Subject: Land North of Water Lane, Angmering: Reserved Matters Application for 525 Residential Dwellings with Associated Parking, Landscaping, Play Areas

The SDNPA have been provided with copies of the additional soft landscaping details submitted to you last week with regard to the above scheme. We have some comments on the additional landscaping, but would first like to emphasise some overarching principles which help integrate new schemes into existing landscapes:

ILLUSTRATIVE SECTION 2

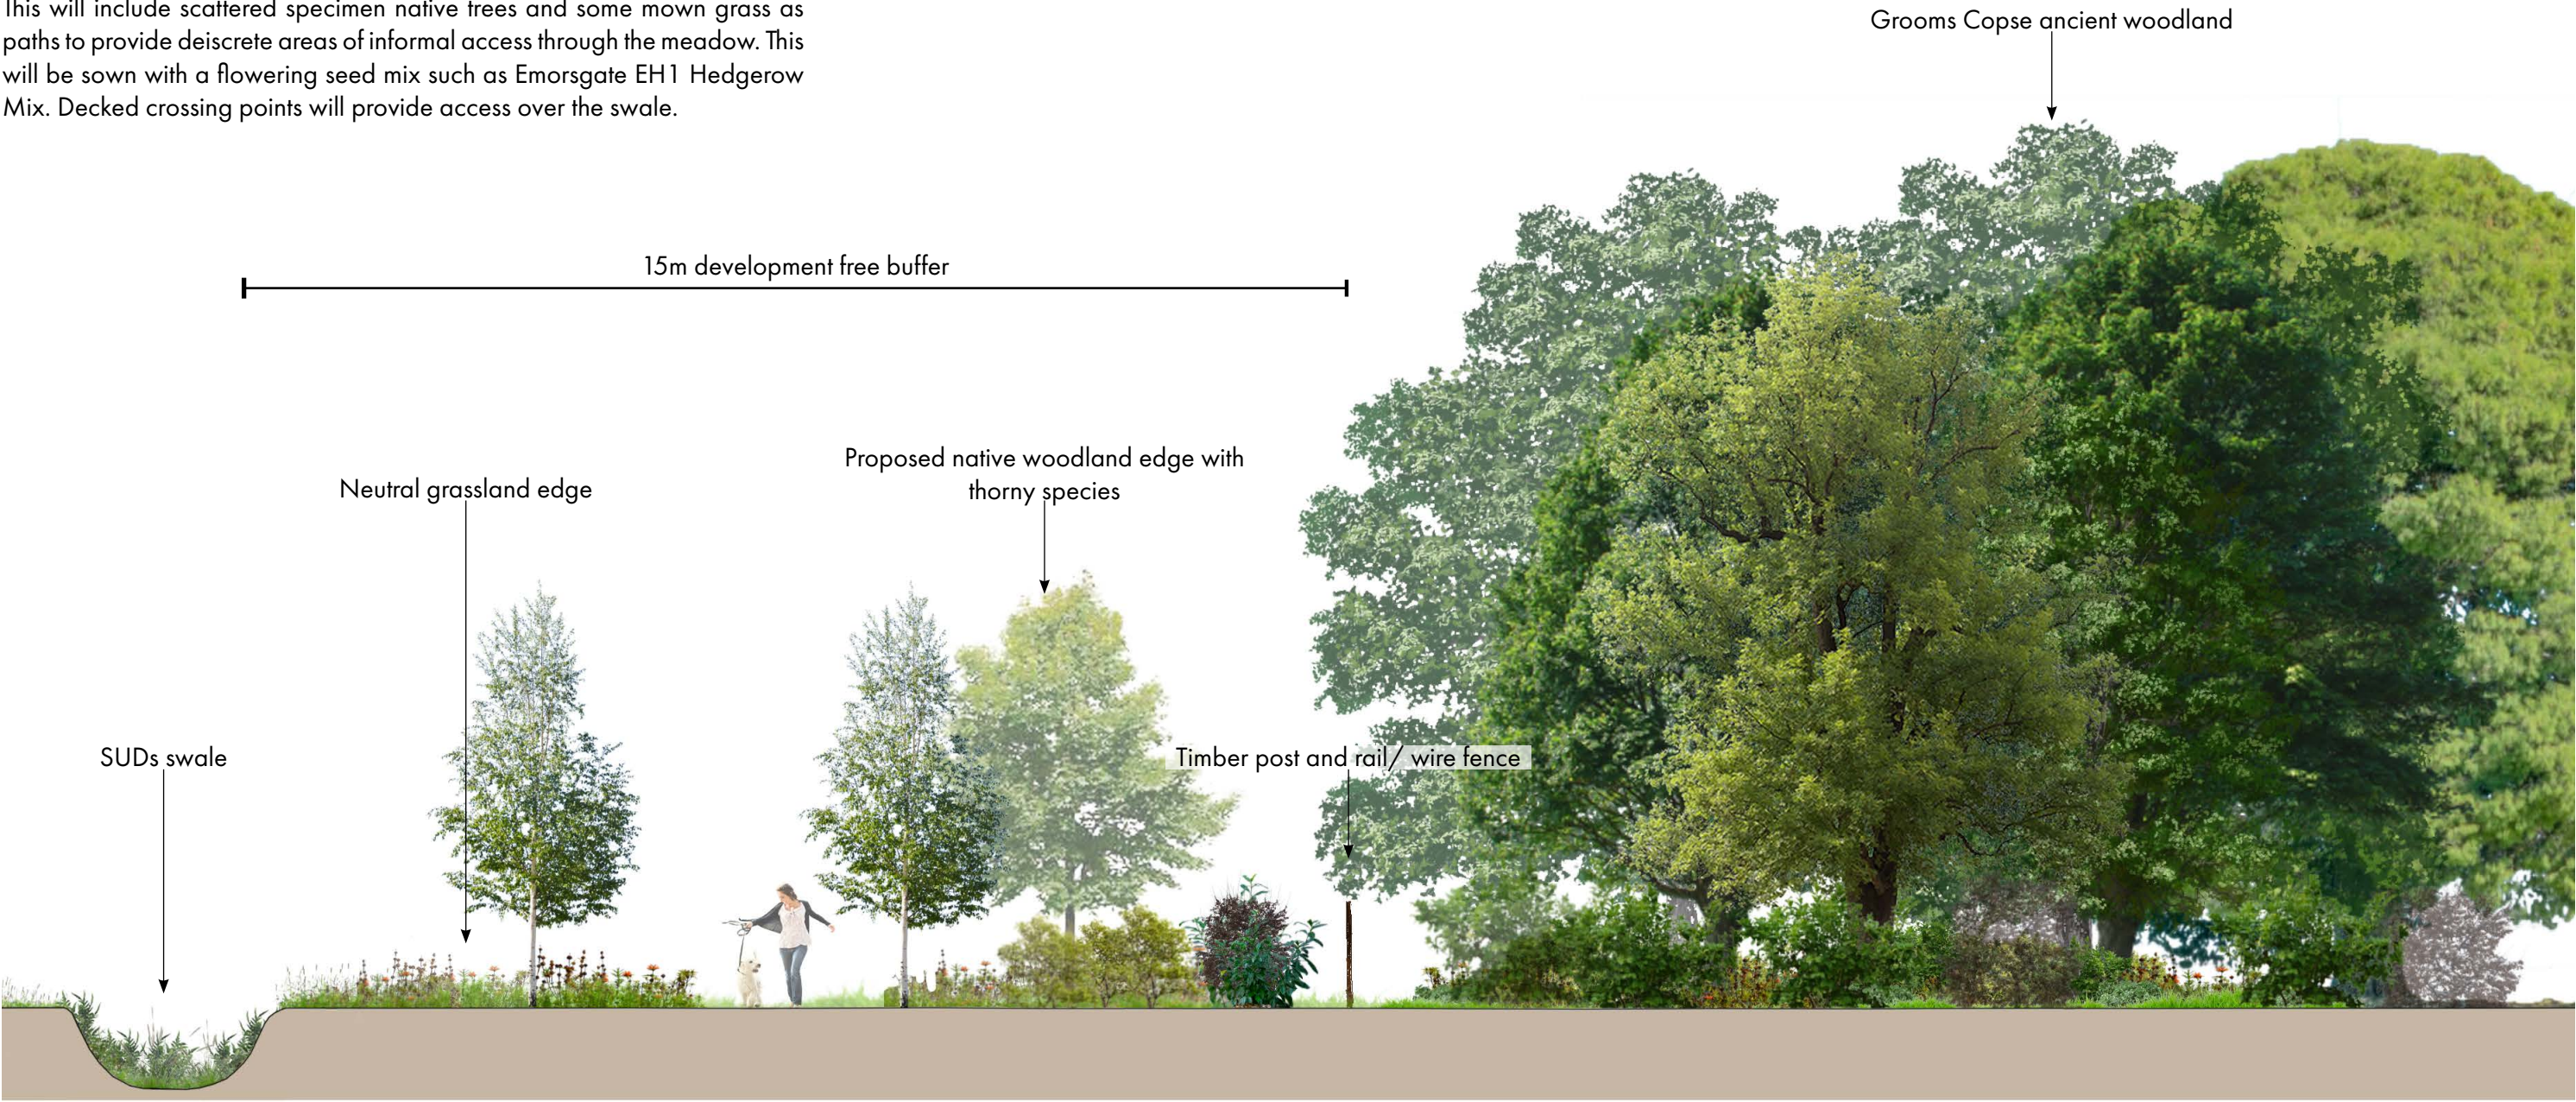
- It would be good to know what type of woodland is being created along the northern boundary. It is important this is meaningful, functional and characteristic. If it is for Dormice, will it be coppiced?

- Any bunding alongside the A27 must be naturalistic in form and capable of supporting the proposed planting in this area.
